Re: Zibi Ontario Phase 1A Response to City of Ottawa Comments related to Transportation

This letter report has been prepared to address to the transportation-related comments received from the City of Ottawa, dated November 24th, 2015 on the preliminary circulation of the Site Plan Application for Zibi Ontario Phase 1A. Previous transportation planning documents prepared by Parsons for the proposed development include: *Domtar Lands Redevelopment - Multi-Modal Transportation Impact Study* dated 21 April 2014; and *Zibi Ontario Phase 1A Transportation Impact Study* dated 4 September 2015. A *Preliminary Multi-Modal Assessment of the Booth Street Corridor* dated 10 December 2015 has also been completed to assist in formulating a construction phasing plan for Booth Street. This was submitted to the City of Ottawa, and is attached.

SITE PLAN

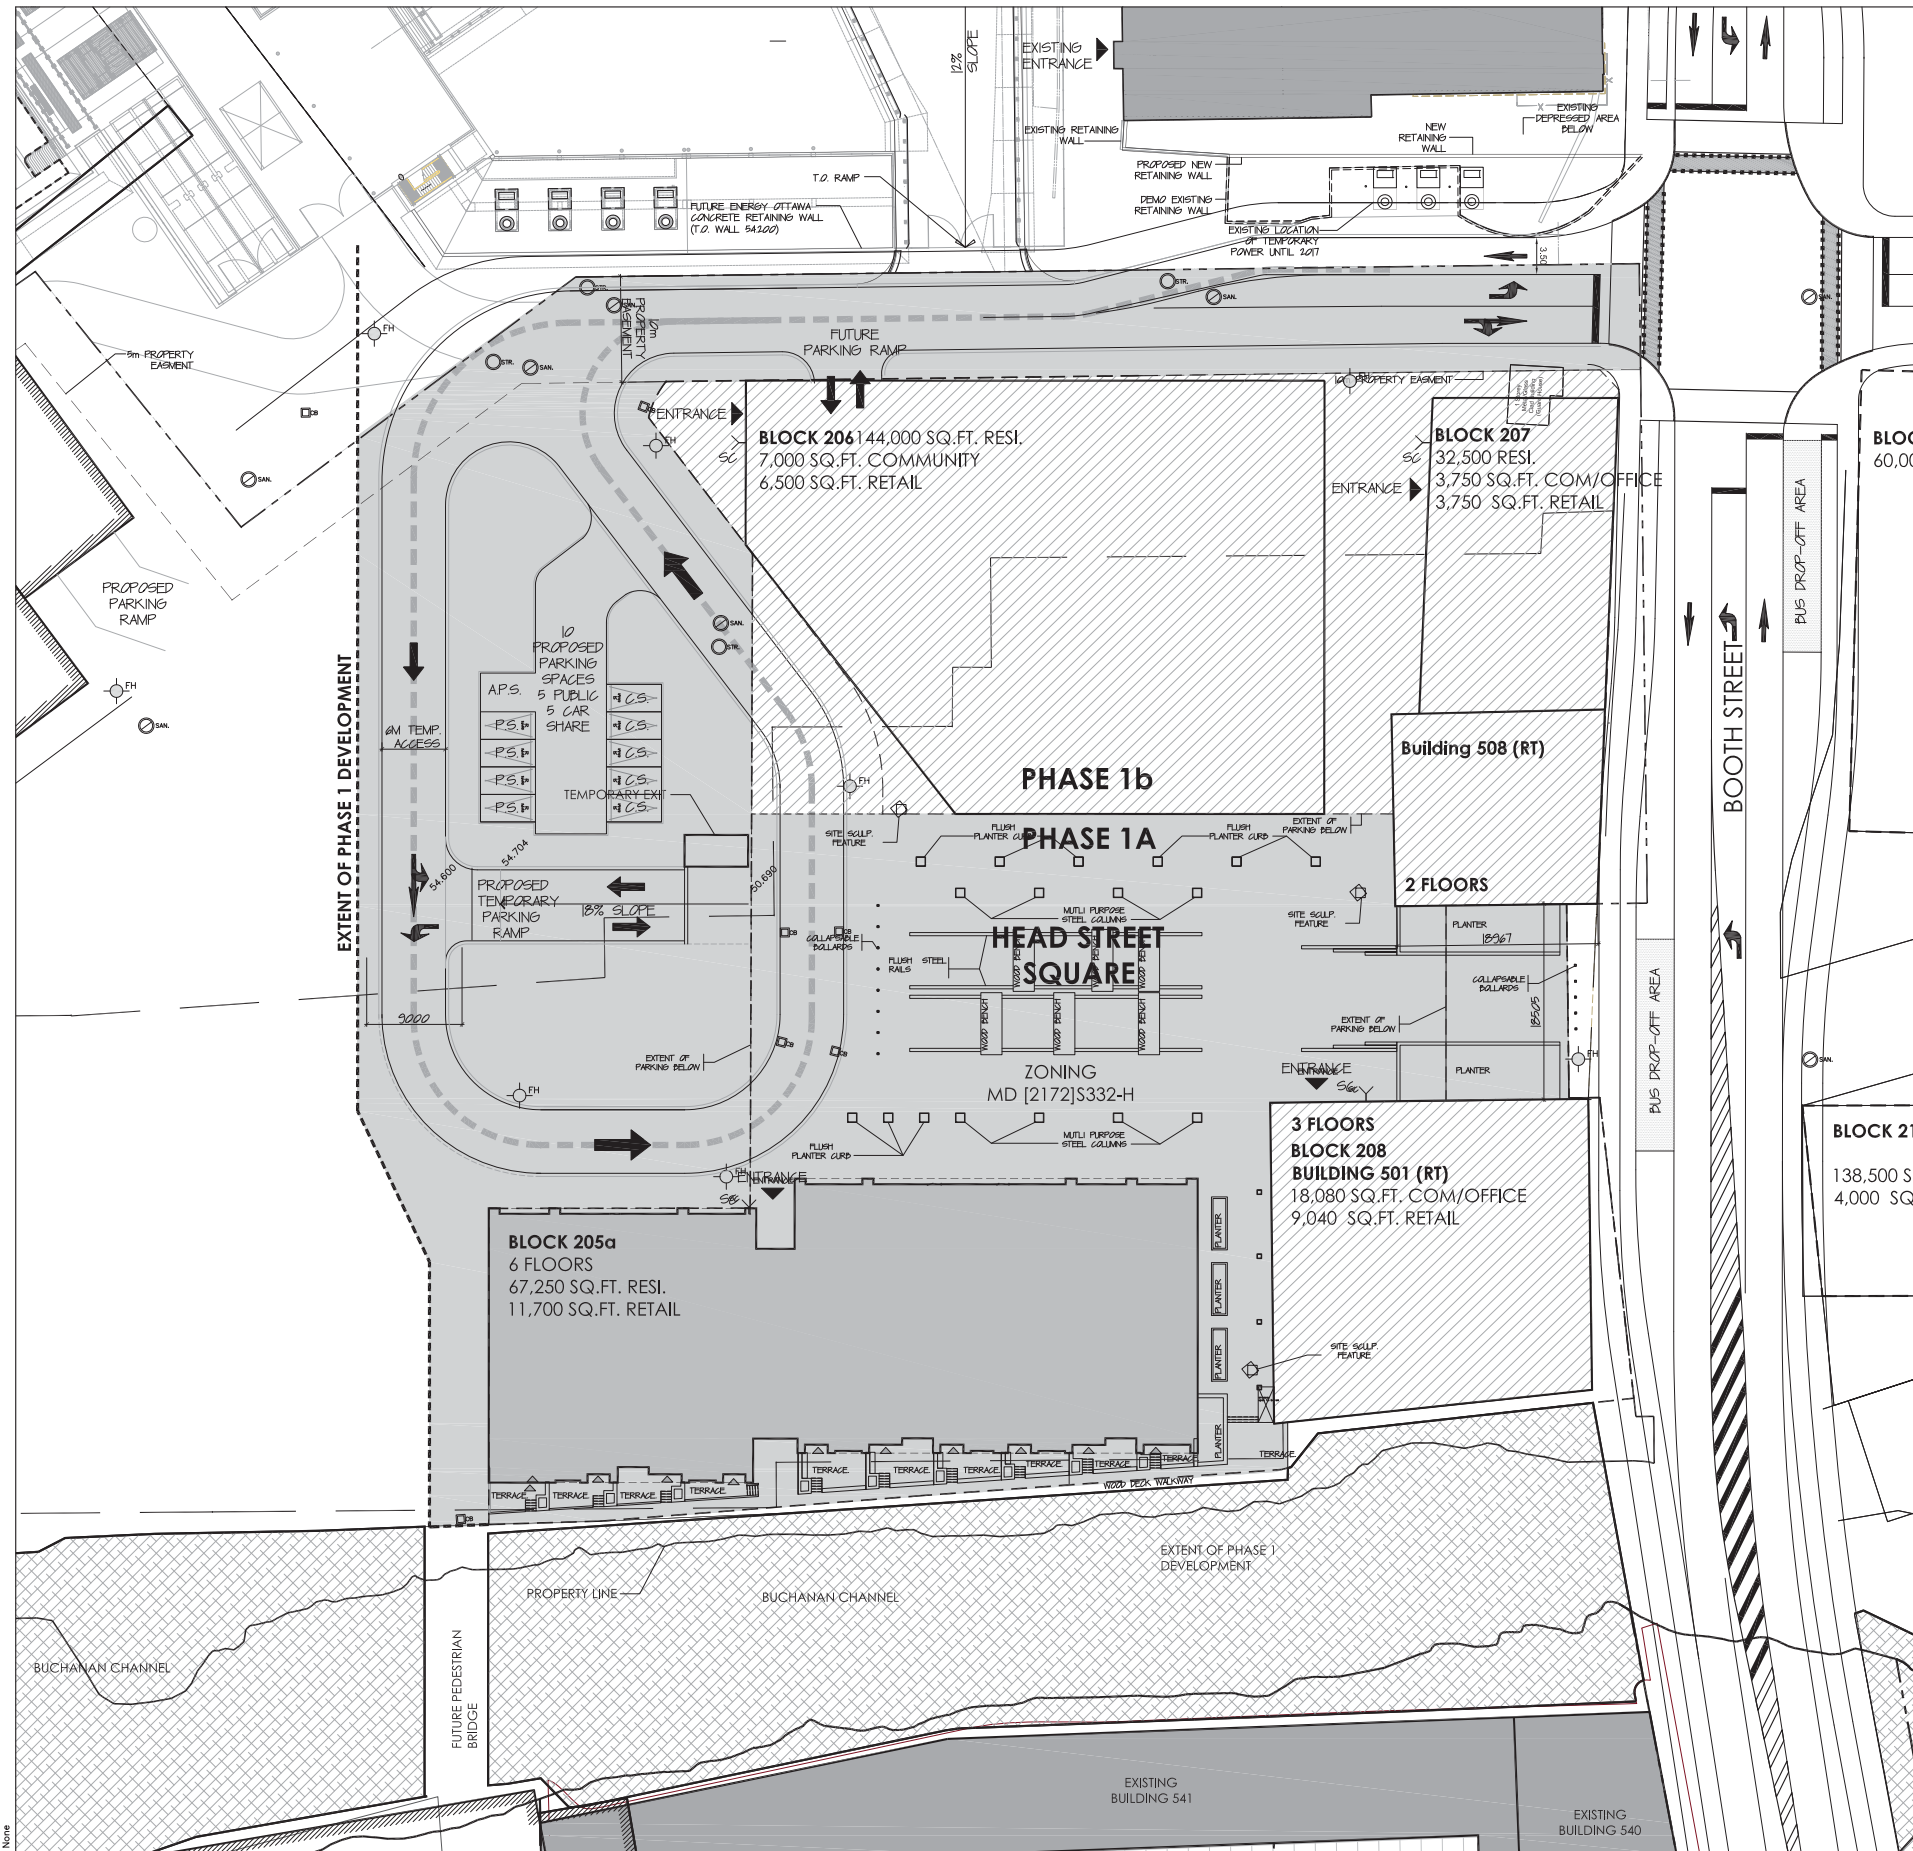
117. The extent of paved areas for pedestrian and cyclists are difficult to read on the site plan within the development and in public ROW. It is difficult to read and understand how this proposal ties into existing and future pedestrian, cycling and multi-use pathway networks. This makes it difficult to ensure that the intent is communicated and that City policy and objectives are being fulfilled. The proponent should resubmit with a plan that clearly identified pedestrian and cycling surfaces along internal roads and along the public streets.

Parsons Response: *An updated sidewalk, pathway and cycling network plan within the site would be beneficial. The Proponent and Architect have been advised.*
